July 21, 2011

Re: 956 Washington Avenue – 161 F010 – R-5 – home occupation – Permit #2011-07-1722

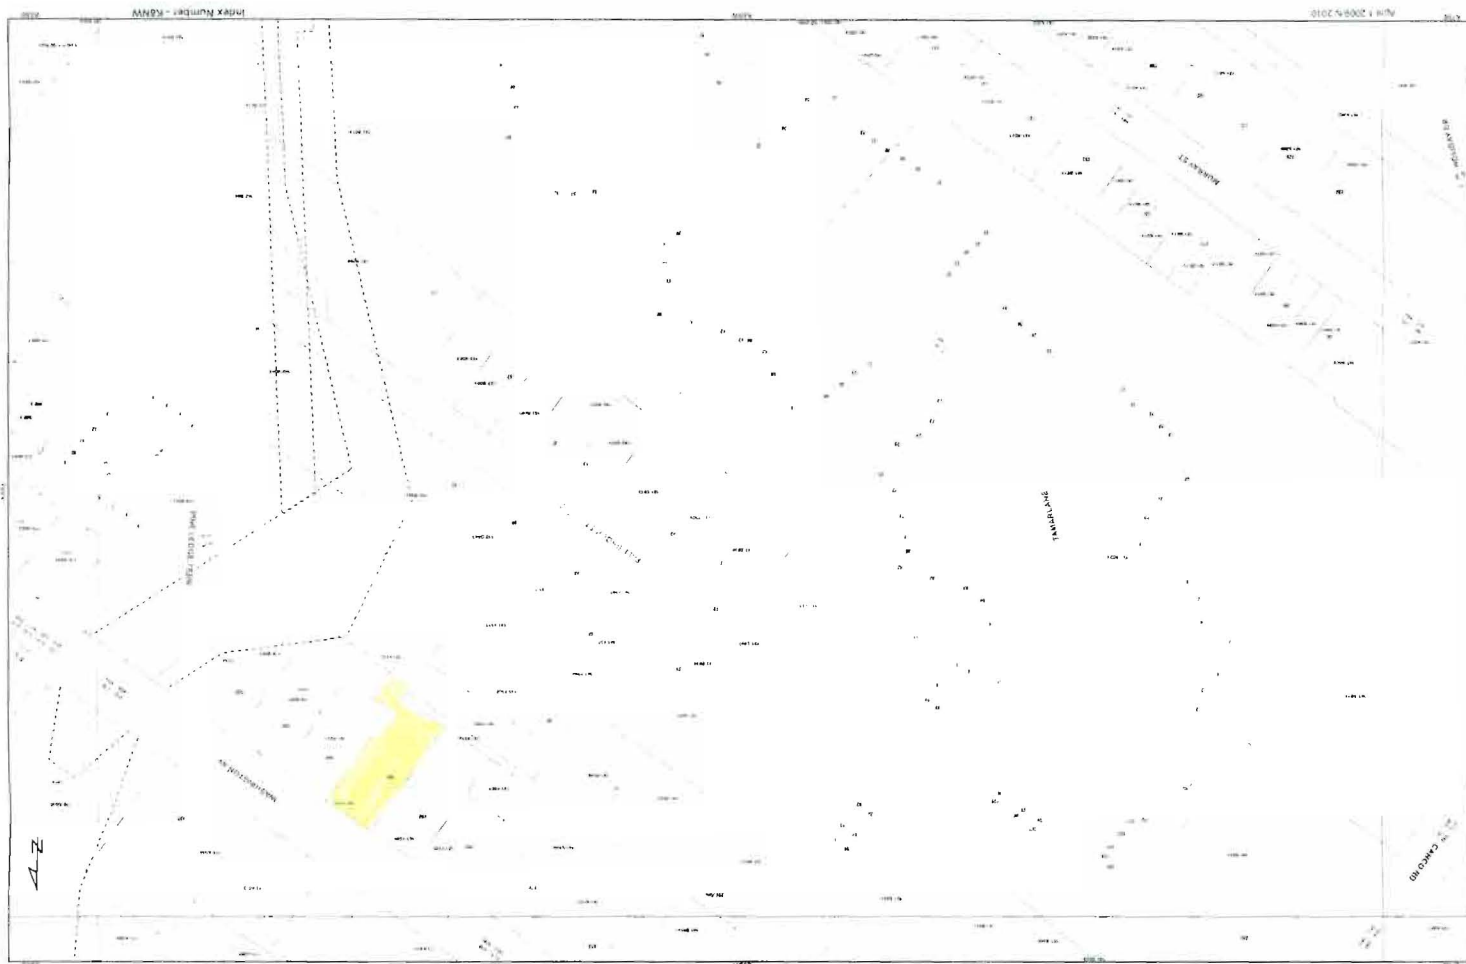
Second, you need to provide a plot plan of the property. The plot plan must include the shape and dimension of the lot, the footprint of any structures and the location and dimensions of parking area(s) and driveway(s).

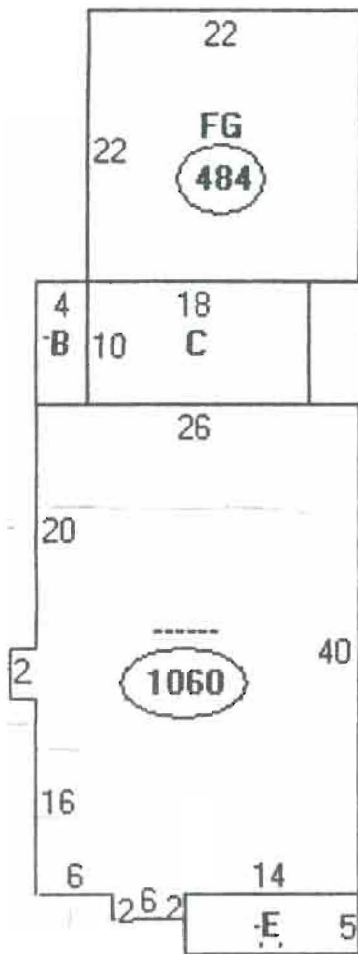
Finally, your floor plan needs to be more accurate. You need to draw the outline of your apartment and then draw the actual rooms with their dimensions, not just the square footage of each room. It does not need to be to scale, but it needs to reflect what is there. This is important to show how you are meeting the criteria for the square footage of the home occupation and the percentage of the area it occupies in your apartment.
